Ribble Valley Borough Council  
Housing & Development Control

Application no: **3/2023/0135**

Address: **114 Clitheroe Road Whalley BB7 9AQ**

Proposal: **Variation of condition 1 (approved plans) of planning permission 3/2020/0803 to allow for first floor accommodation.**

# Land off Clitheroe Road, Whalley - Proposed Floor Plans

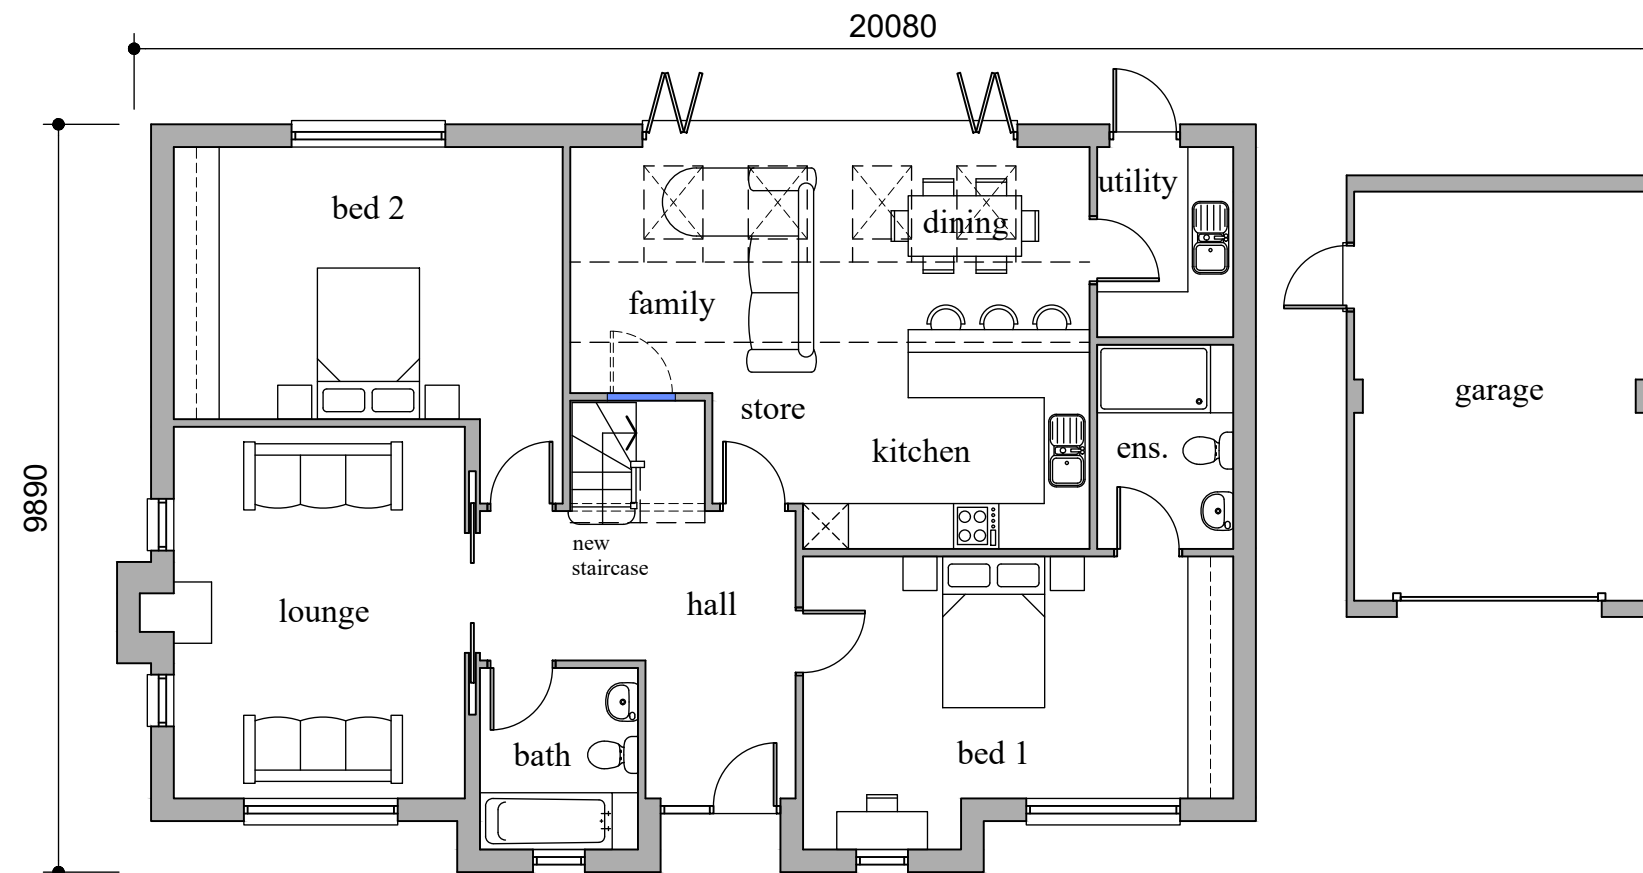
The LHA have reviewed the amended plans which include PWL drawing number 1305-PL15 titled "Proposed Floor Plans" and are aware that should the condition be varied then the proposed 2 bed dwelling will become a 4 bed.
